Application No: LU/46/20/PL
Site Address: Littlehampton Covered Market 26-28 Surrey Street Littlehampton BN17 5BG
Description of works: Demolition of existing building & construction of 1 No retail unit & 3 No. flats with associated external works & access. This application affects the setting of listed buildings & may affect the character & appearance of the River Road, Littlehampton Conservation Area.

LU/46/20/PL
26-28 SURREY STREET, LITTLEHAMPTON

The Littlehampton Society wishes to comment on the amendments to this application as follows:

Proposed Plans And Elevations

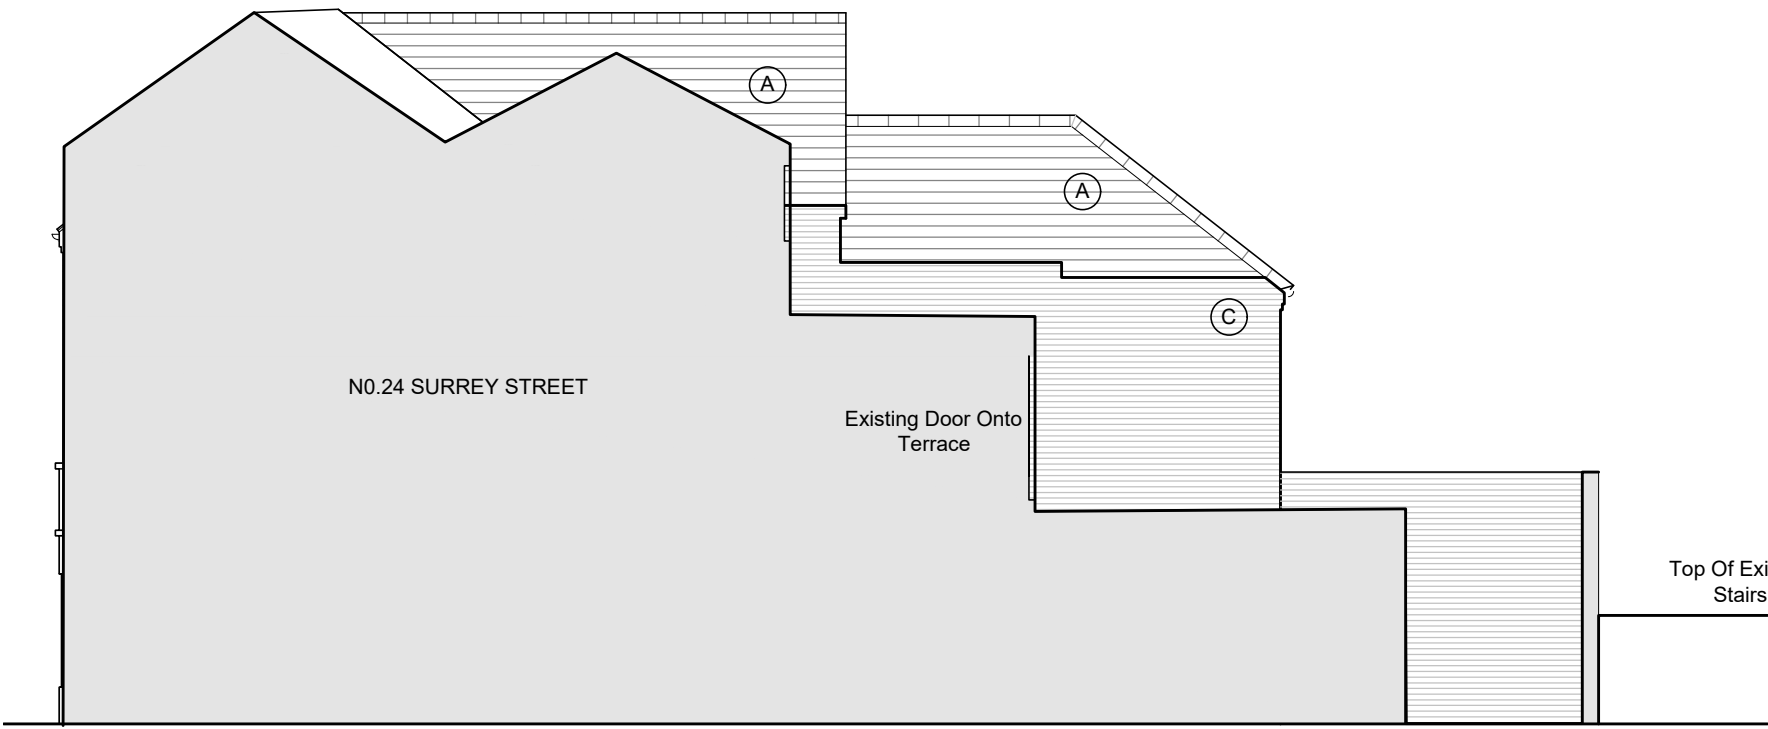
(1) The use of pvcu sash windows, even though they may be 'conservation grade', is simply not satisfactory given the site's location so near to designated heritage assets. As mentioned before, they need to be painted timber vertically sliding sash windows in order to protect the setting of nearby listed buildings and the conservation area.

(2) The use of fibre cement slates is also unsatisfactory due to their absolute regularity in shape and

propensity over time for their colour to fade and to attract visually unsuitable lichens rather than the attractive patina of natural slates. Natural slates exist on the roofs of the adjoining and nearby listed buildings and the use of fibre cement slates will, again, detract from the setting of these historic buildings and the conservation area. For these reasons, natural slates should be used on the roofs of the proposed development.

(3) There is a mixture of rendered and brick facades in the locality and the use of an appropriately coloured render would make the new building more of a focal point in the street scenes. It also avoids the possibly clumsy appearance of the relationship of a new brick facade immediately abutting the old brick facade of 24 Surrey Street if the brickwork colour, pointing and bond is not quite right. Render could work well and the introduction of a black painted plinth around the base of the new building would enhance its appearance. If render is to be used then rendered flat splayed arches over the window heads would be more appropriate than the brick segmental arches shown on the plans.

(4) In this sensitive location lead should be used for the roofs and cheeks of the dormer windows shown on the plans.
